**From:** June Pagdin  
**Sent:** 20 March 2018 11:47  
**To:** Emily Stainer  
**Subject:** FW: 6/2017/2513/FULL 33-34 Salisbury Square Hatfield AL9 5AF Conversion of existing ground floor (Class A3) restaurant to form two (2xbed) flats (Class C3) including part demolition and extension at ground and first floor (rear) with associated external a

**From:** Vikki Hatfield  
**Sent:** 15 March 2018 11:35  
**To:** June Pagdin <j.pagdin@welhat.gov.uk>  
**Subject:** FW: 6/2017/2513/FULL 33-34 Salisbury Square Hatfield AL9 5AF Conversion of existing ground floor (Class A3) restaurant to form two (2xbed) flats (Class C3) including part demolition and extension at ground and first floor (rear) with associated external a

**Drawing**  
**Site Plan**

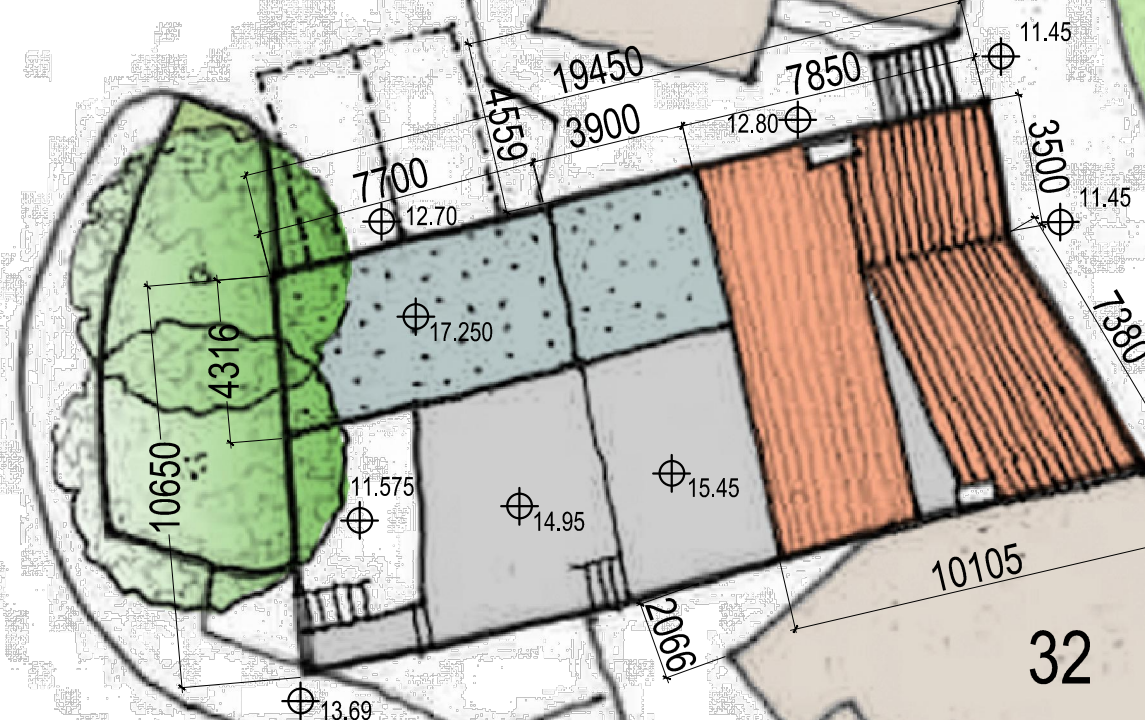
Apologies as this email is a little after the deadline of the 8<sup>th</sup> March.  
In the design and access statement it refers to two parking spaces in the car park, but after looking at the boundary plan and land registry it doesn't appear to indicate where these are and if indeed they actually have these spaces. Can you find out where they are supposedly located?

In addition, two parking spaces for 2xtwo bed flats are not likely to be adequate for this development. However, in theory, they would meet the standards.
